Estates at Cathedral Pines  
Trip Generation & Access Technical Memo  
(LSC #S224150)  
EPC PCD File No. PUDSP2210 & SF2234  
January 8, 2024

**LSC Responses to  
TIS redline comments**

**WINSLOW DR PROFILE
STA 5+50.00 TO 10+50.00**

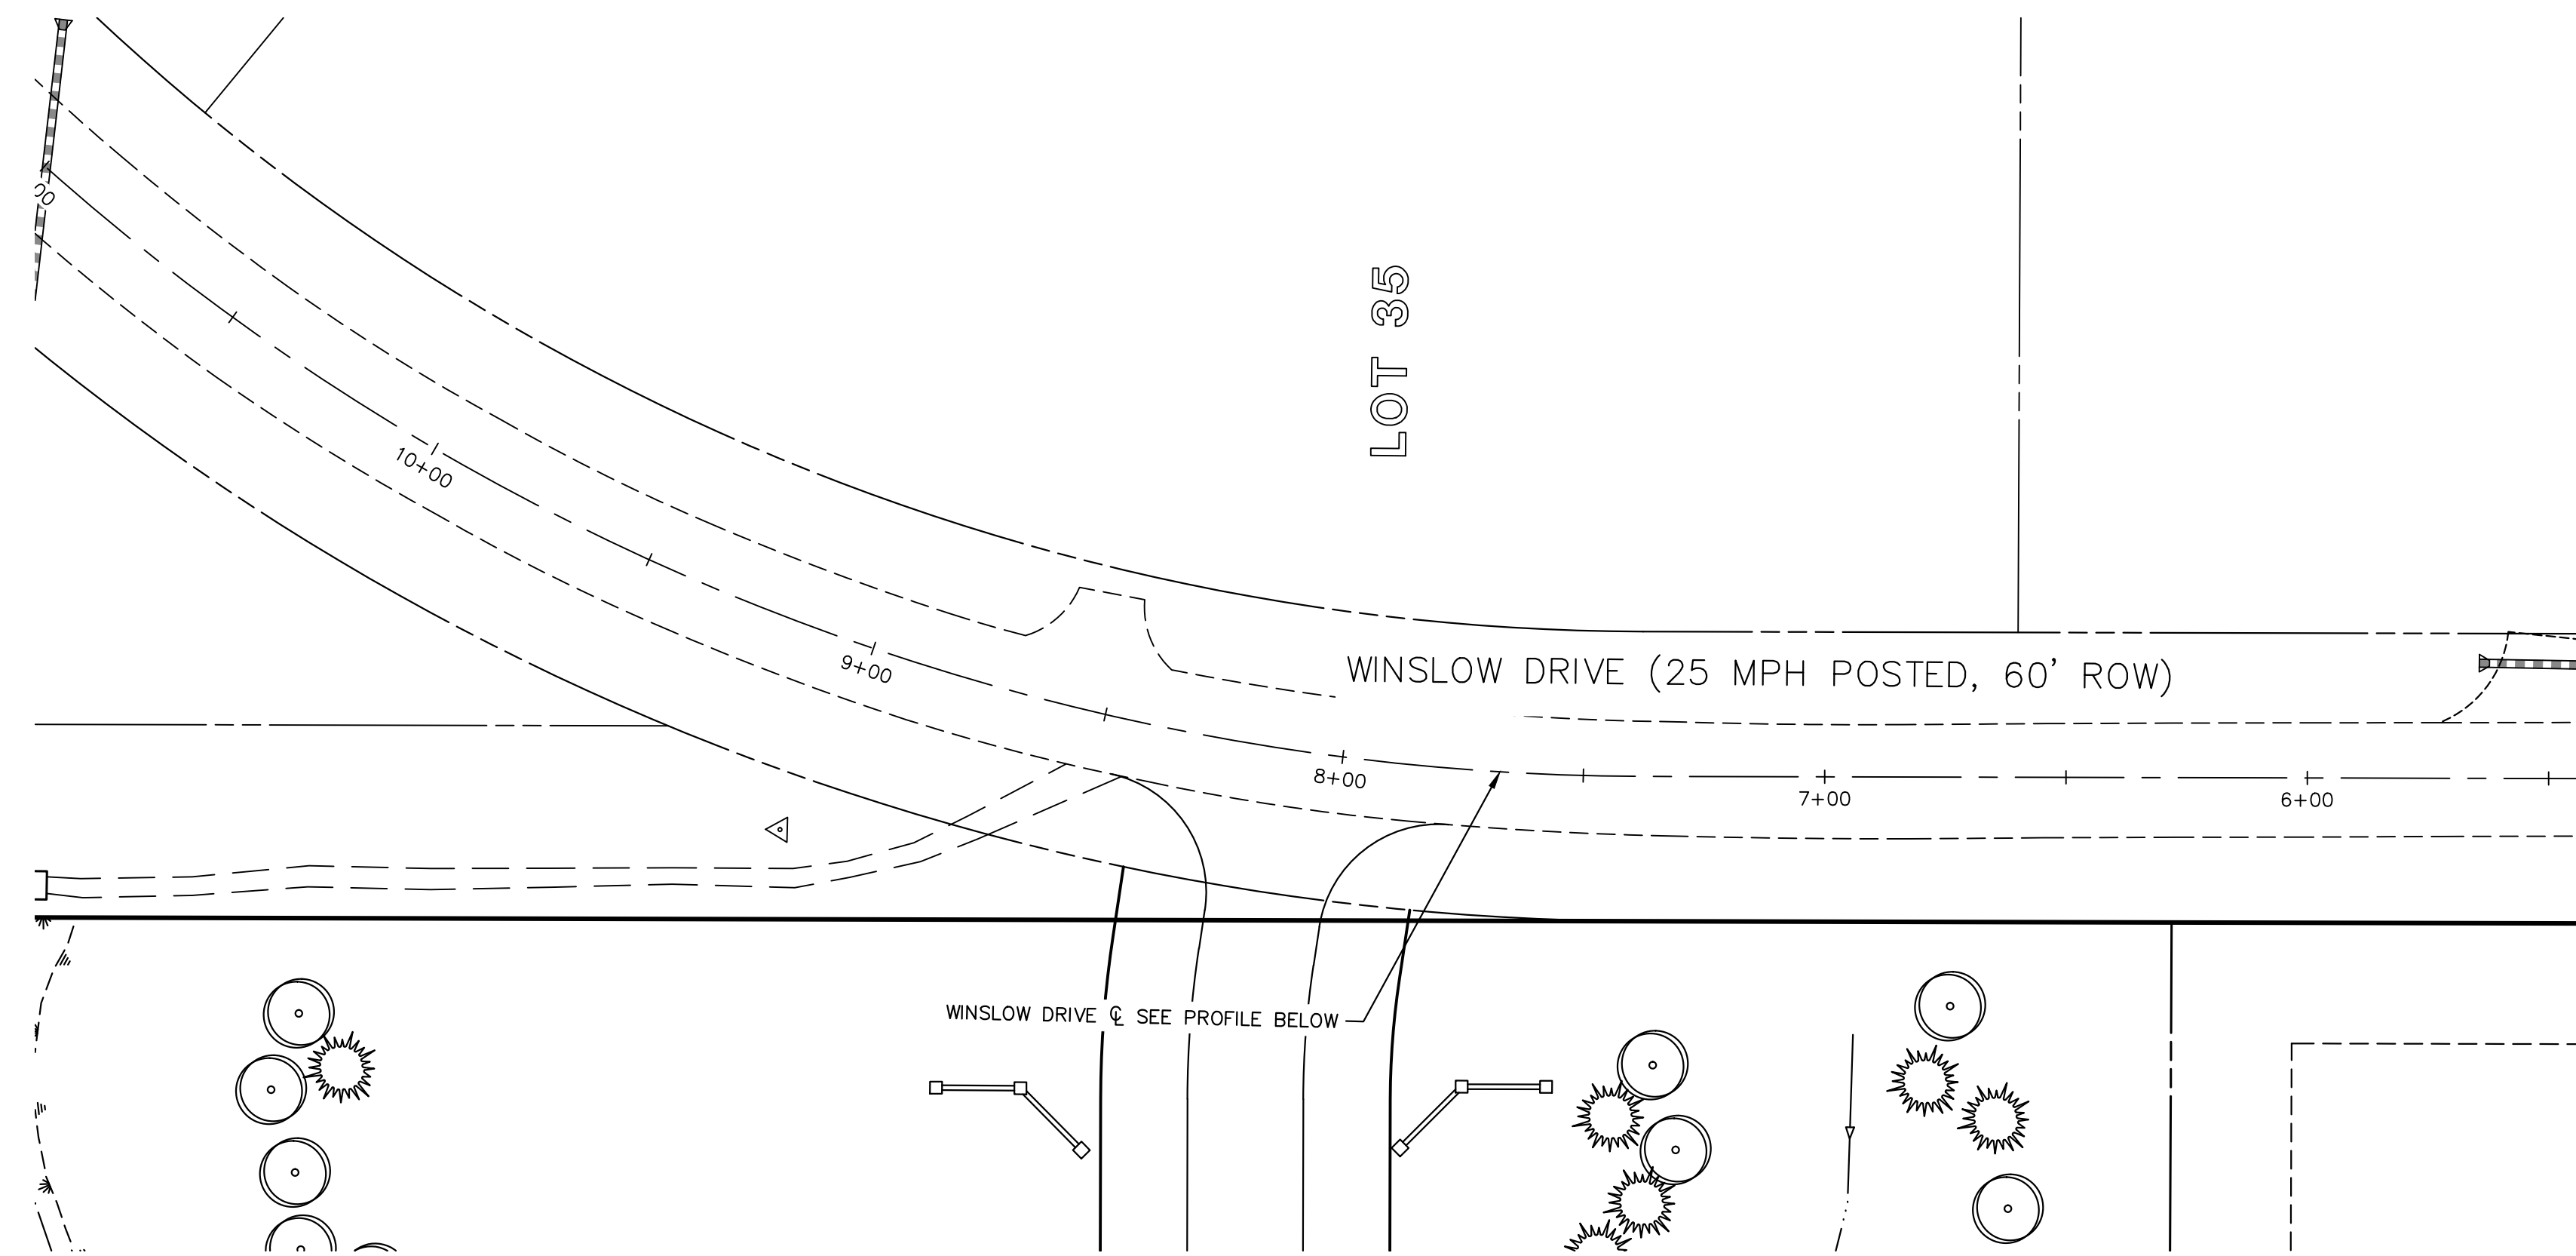
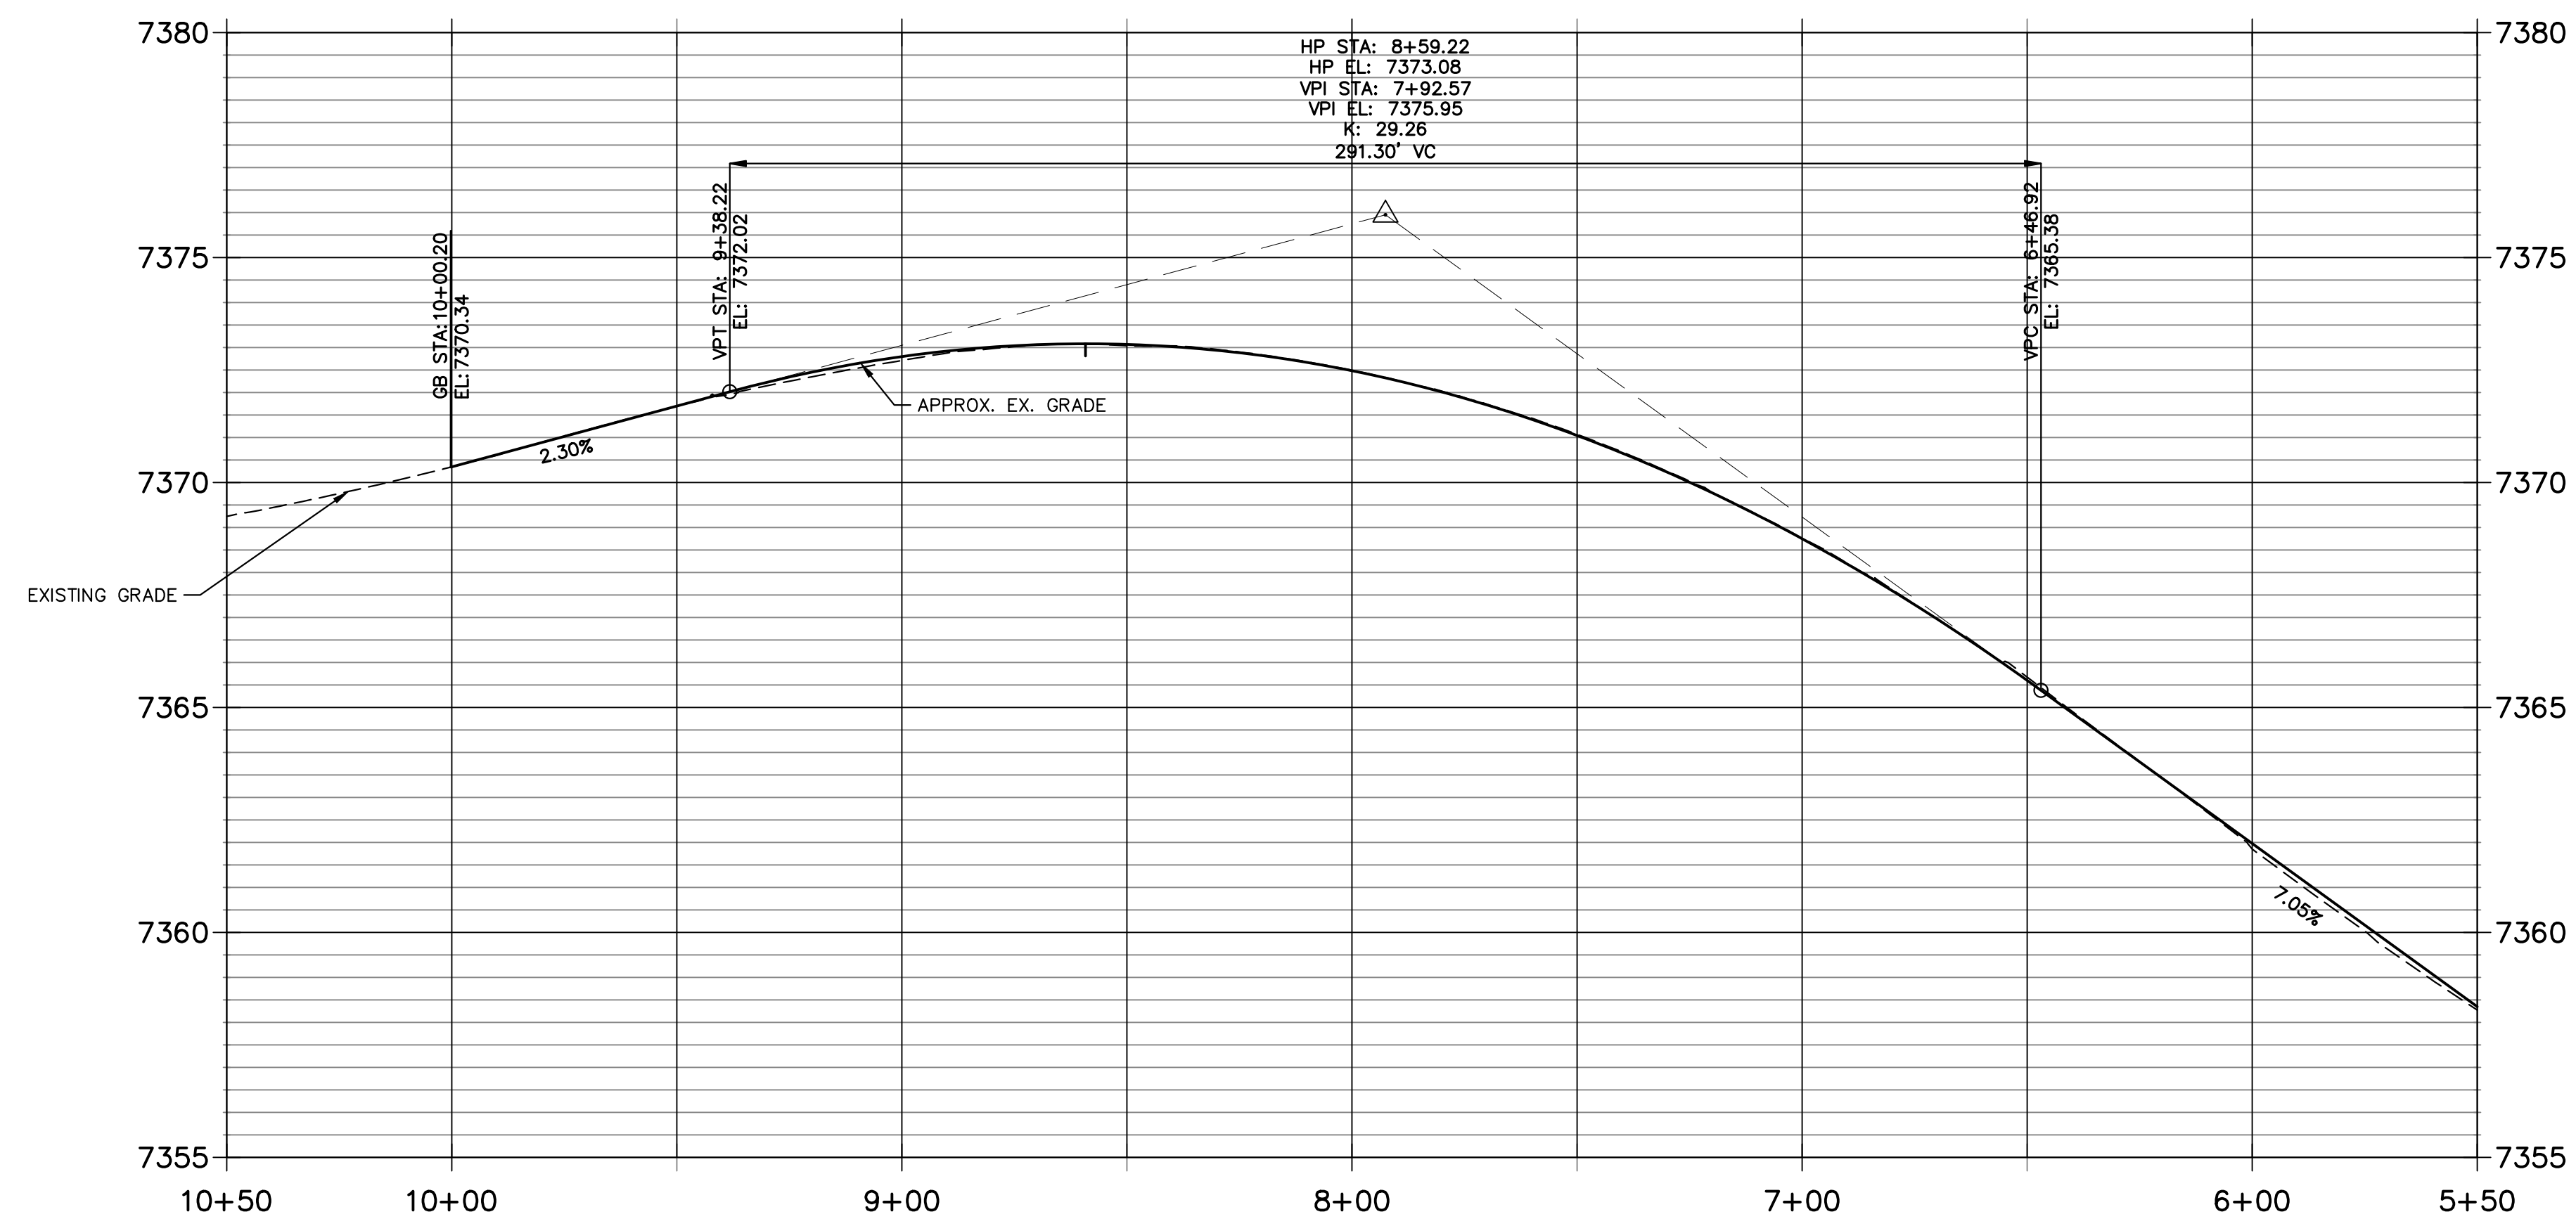
3 Provide exhibit of intersection sight distance and state what the sight distance specifically is. The stopping sight distance exhibits do not depict the intersection sight distance.

Provide exhibit that shows intersection sight distance Per Table Table 2-21 and Figure 2-33

LSC Response: Intersection/entering sight distance has been added to the TIS.
